ENG-SF21032-R1-CDs.pdf Markup Summary

Subject: Text Box
Page Index: 1
Date: 11/24/2021 2:18:06 PM
Author: dsdrice
Color: ■
Layer:
Space:
Page Label: [1] 1 CV01- Street Plans - CV01

STERLING RANCH FILING 3
 STORM SEWER PLAN
 SHEET 3 OF 7
 JOB NO. 25188.00

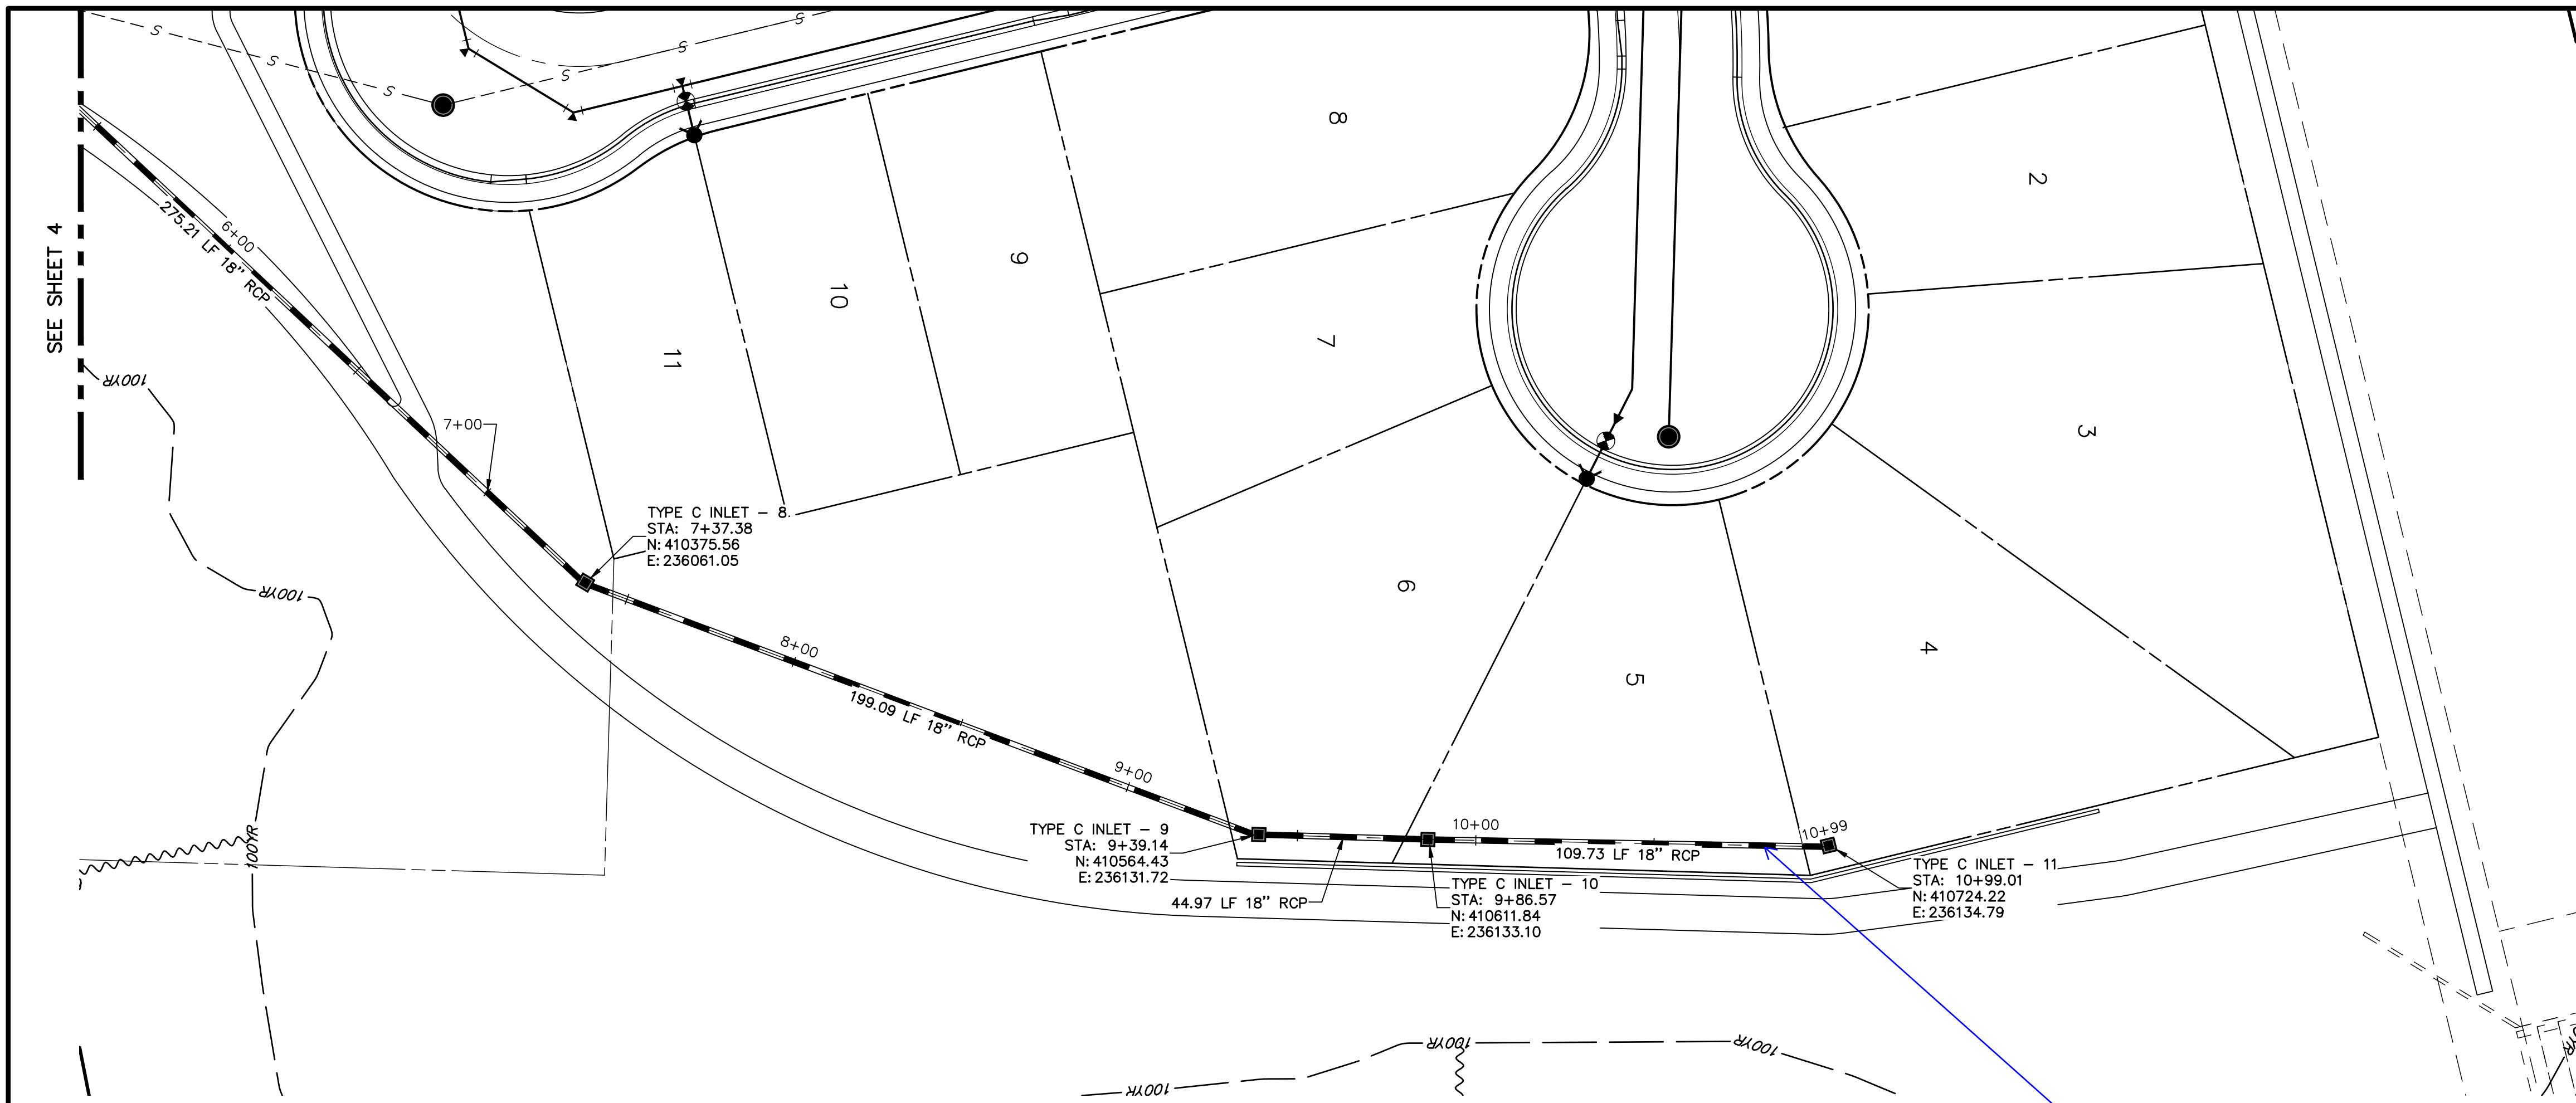
HGL shouldn't be above the pipe for long runs. Will 36" pipe or steeper slope correct this?

**HAZLETT DR PROFILE
STA 0+00.00 TO 5+50.00**

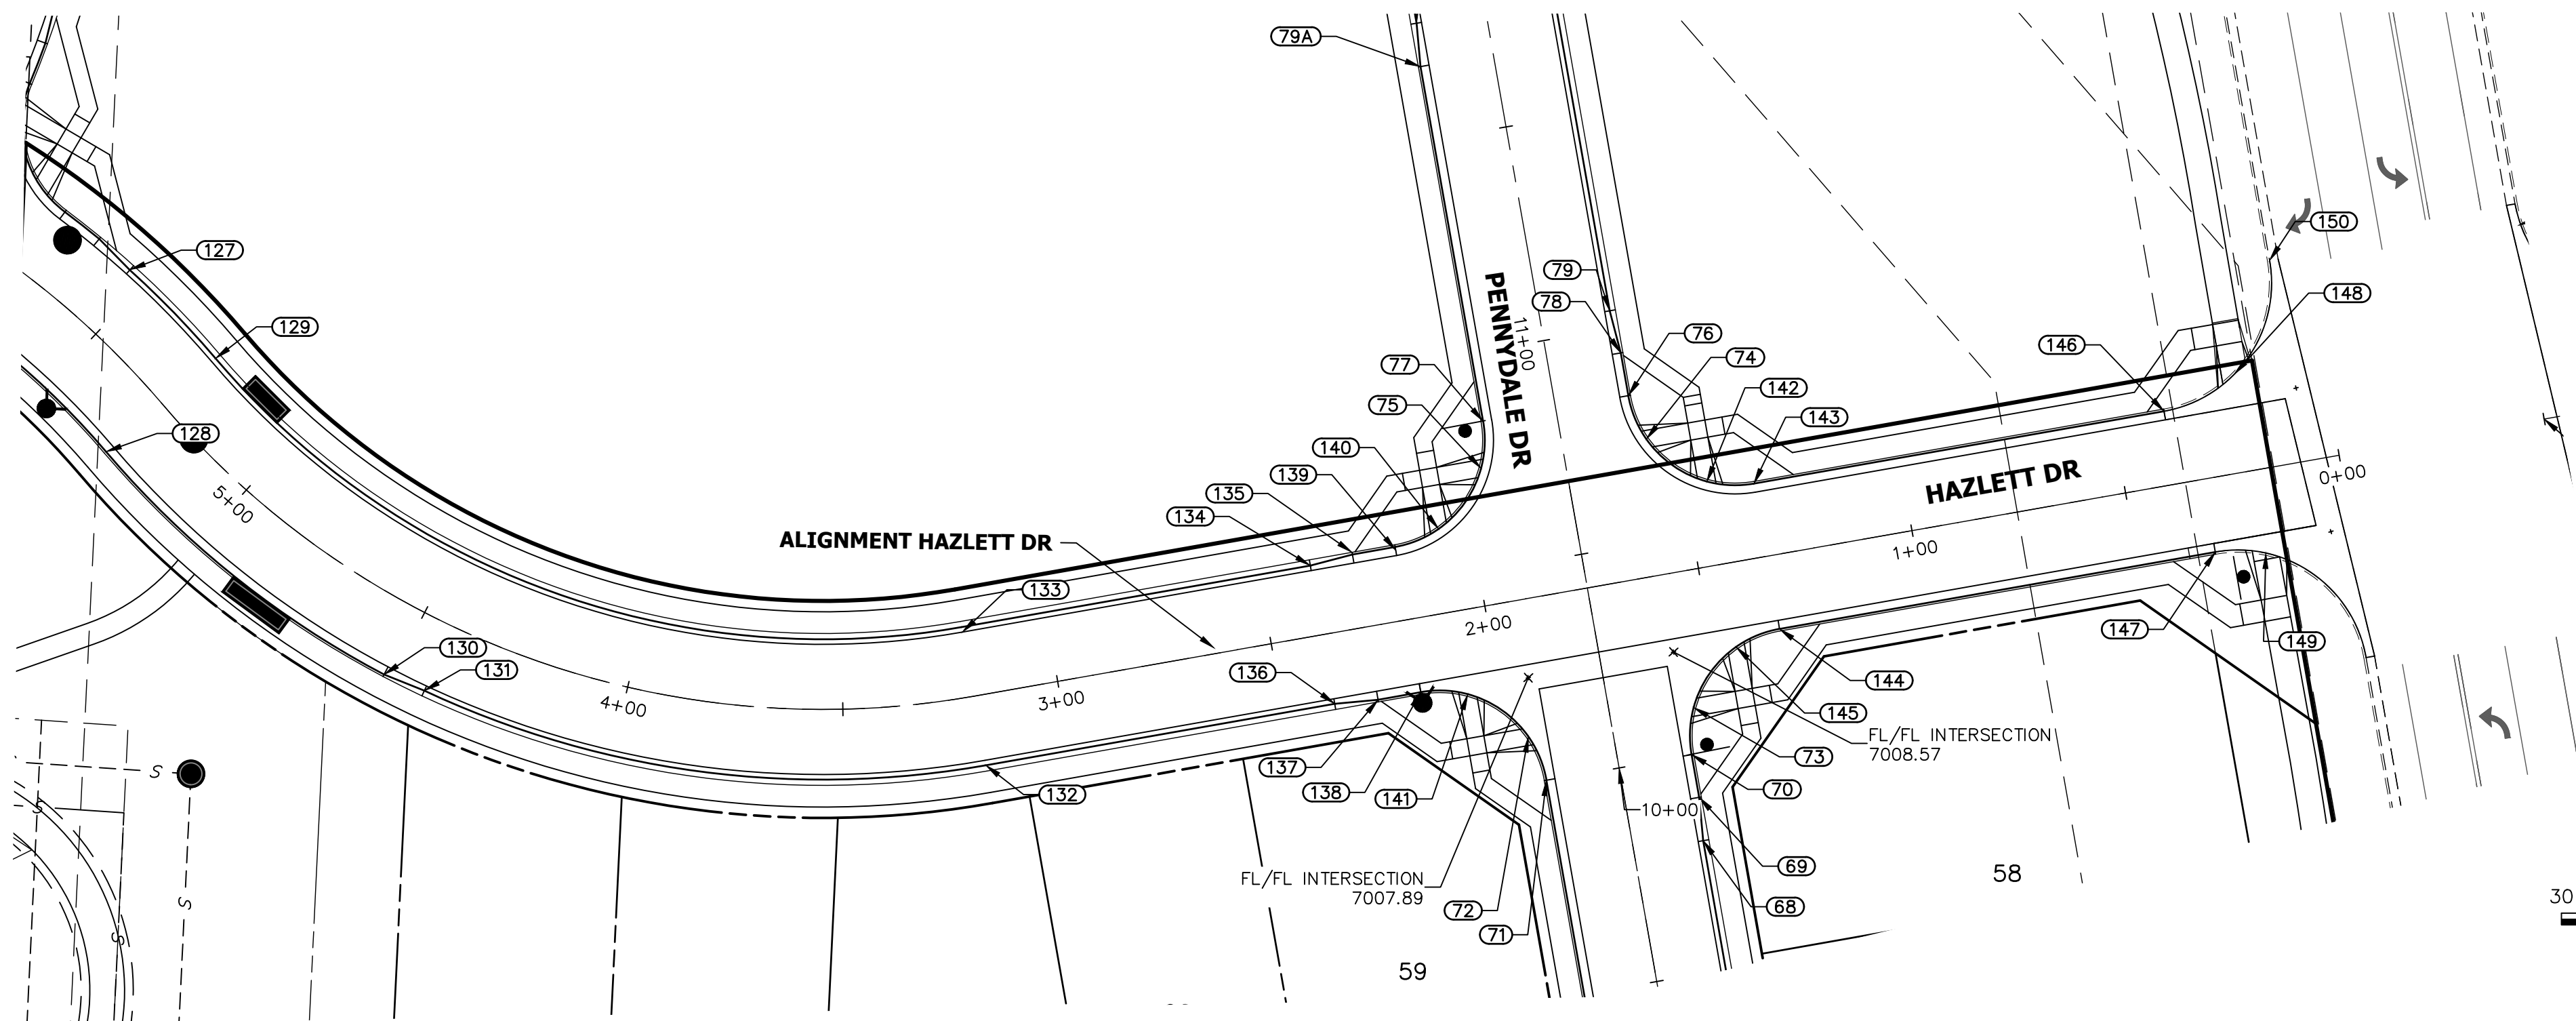
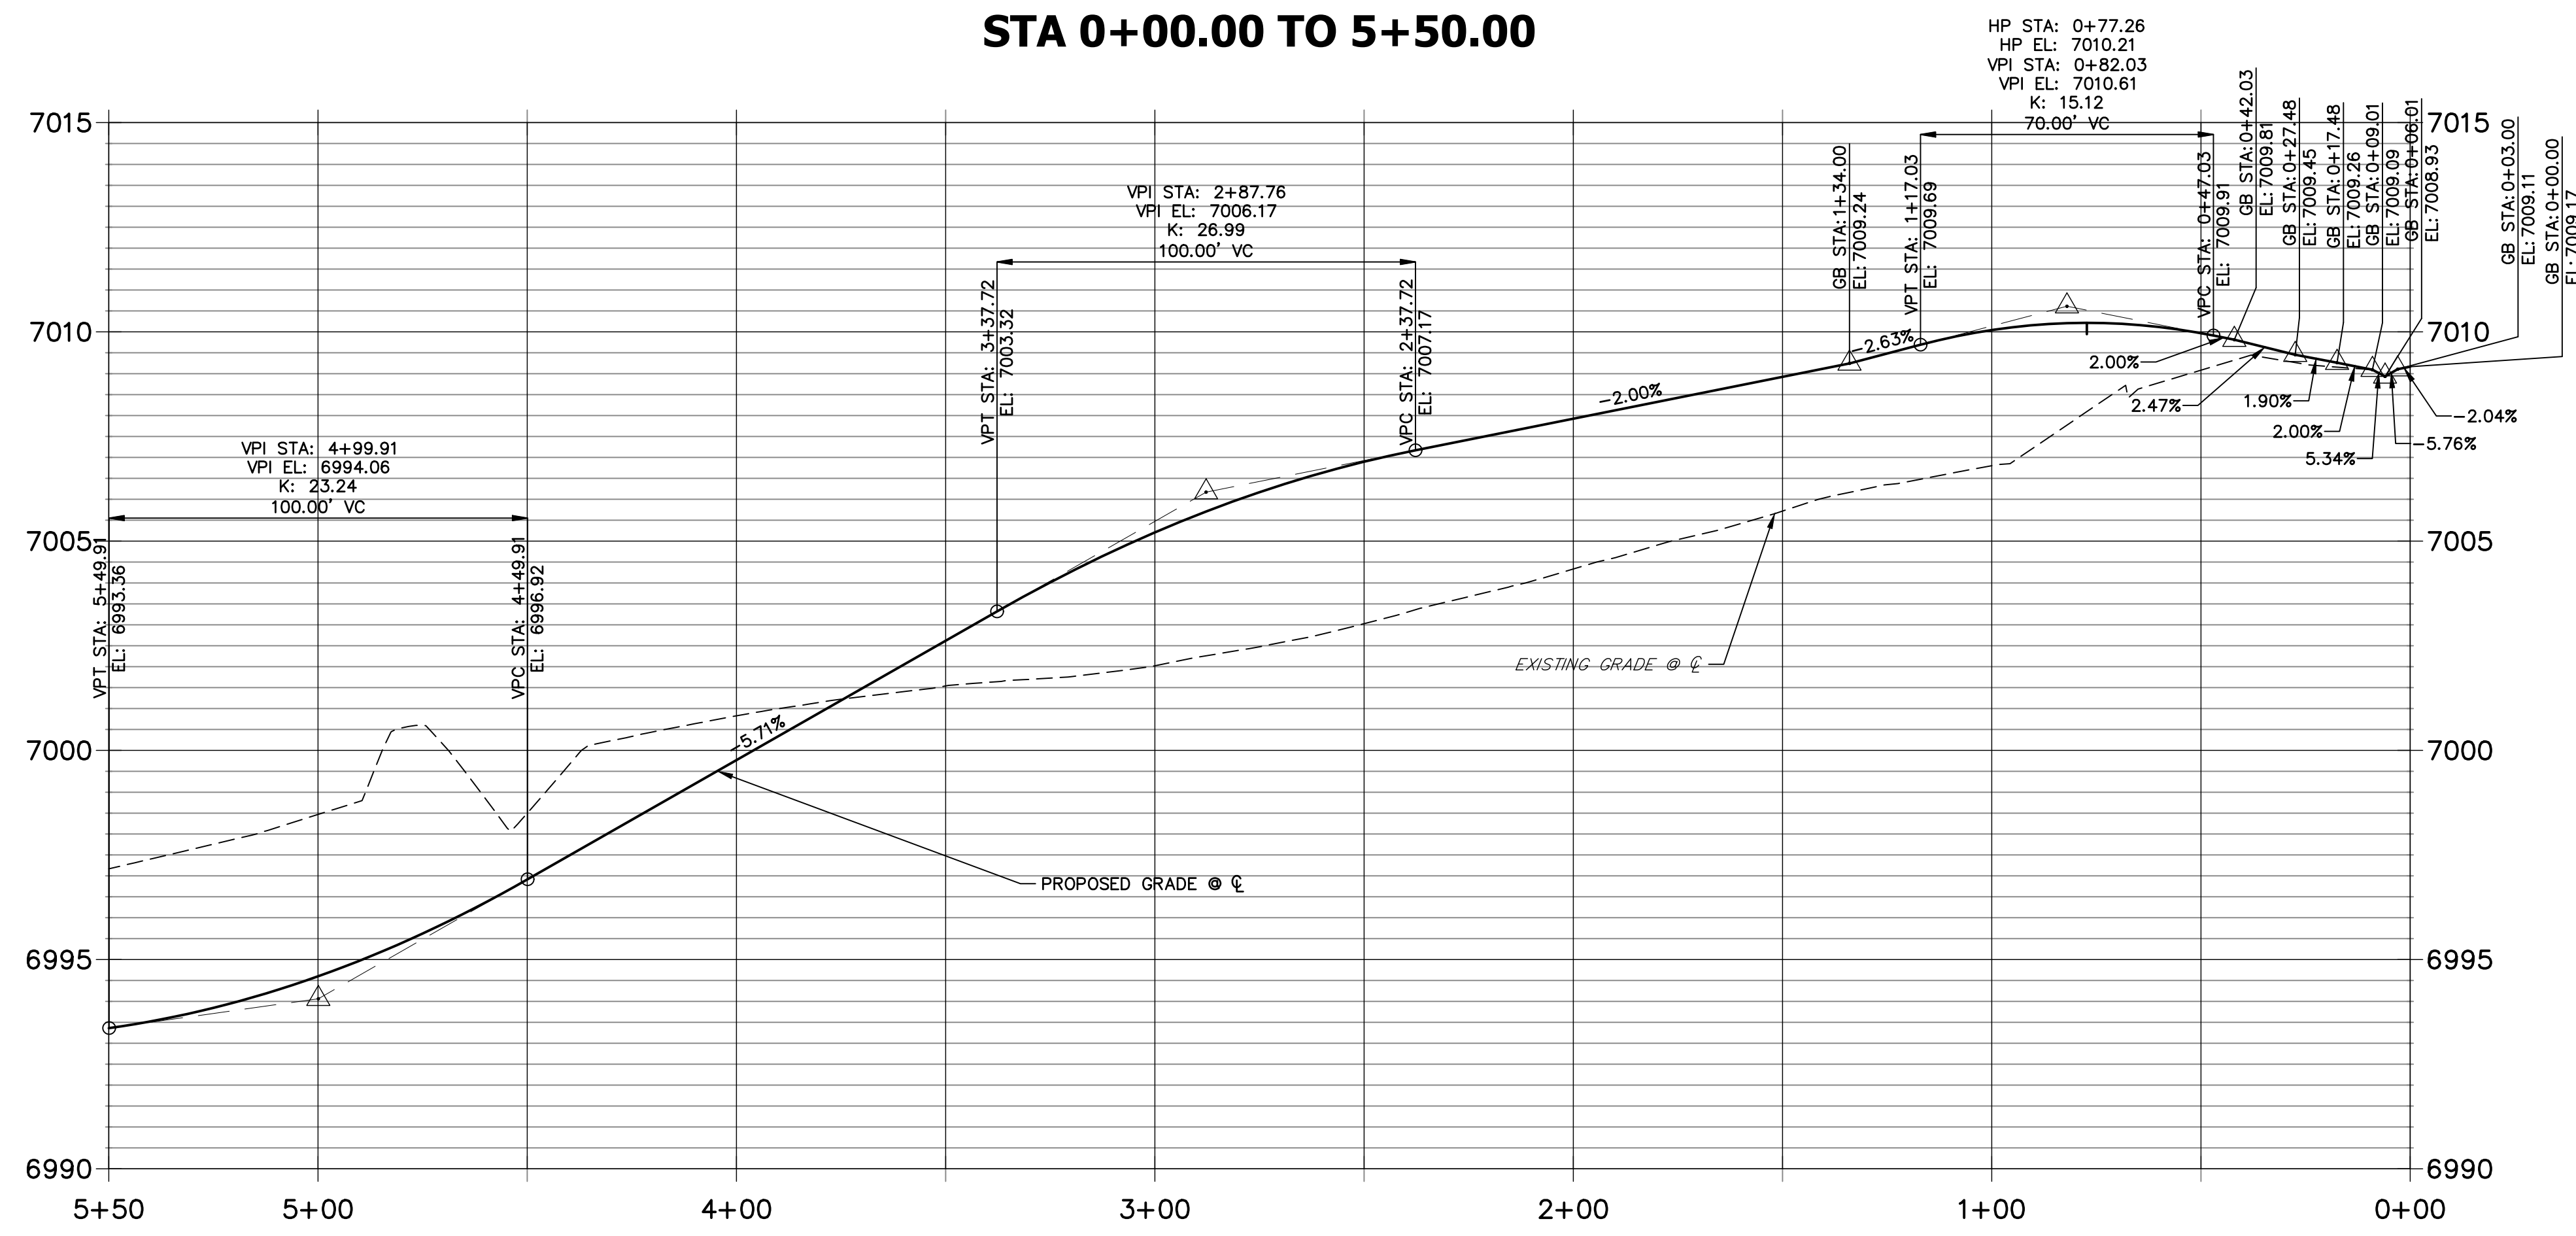
provide slope to meet ADA requirements (<2%)

**STERLING RANCH PHASE 2 EX. GAS LINE PROFILE
STA 0+00.00 TO 10+78.71**

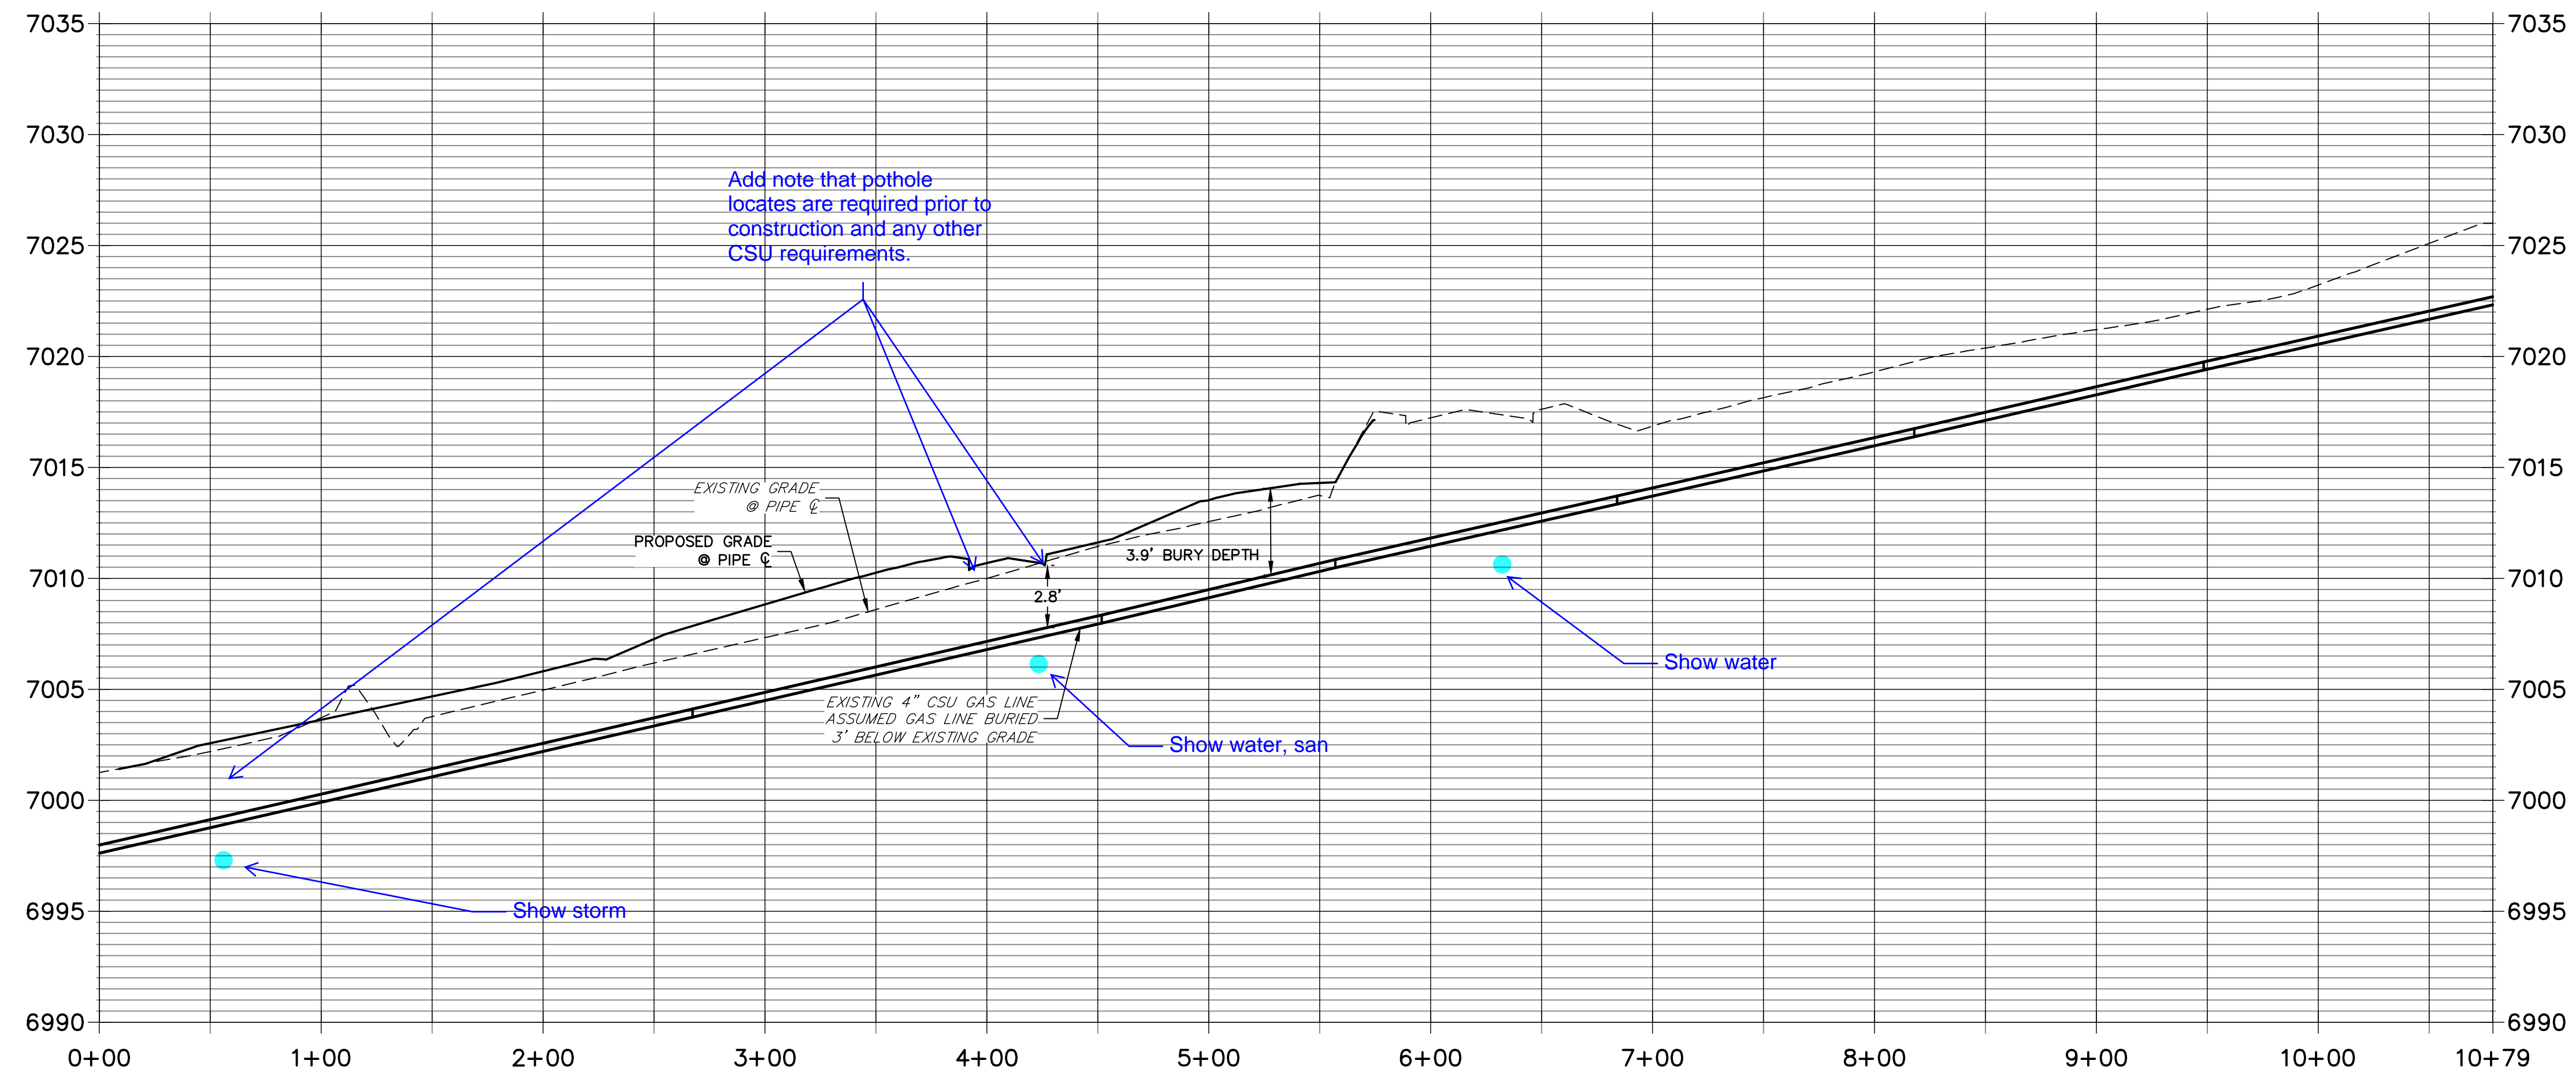
label bury depth. Provide a profile along the gas main showing cover and crossings.
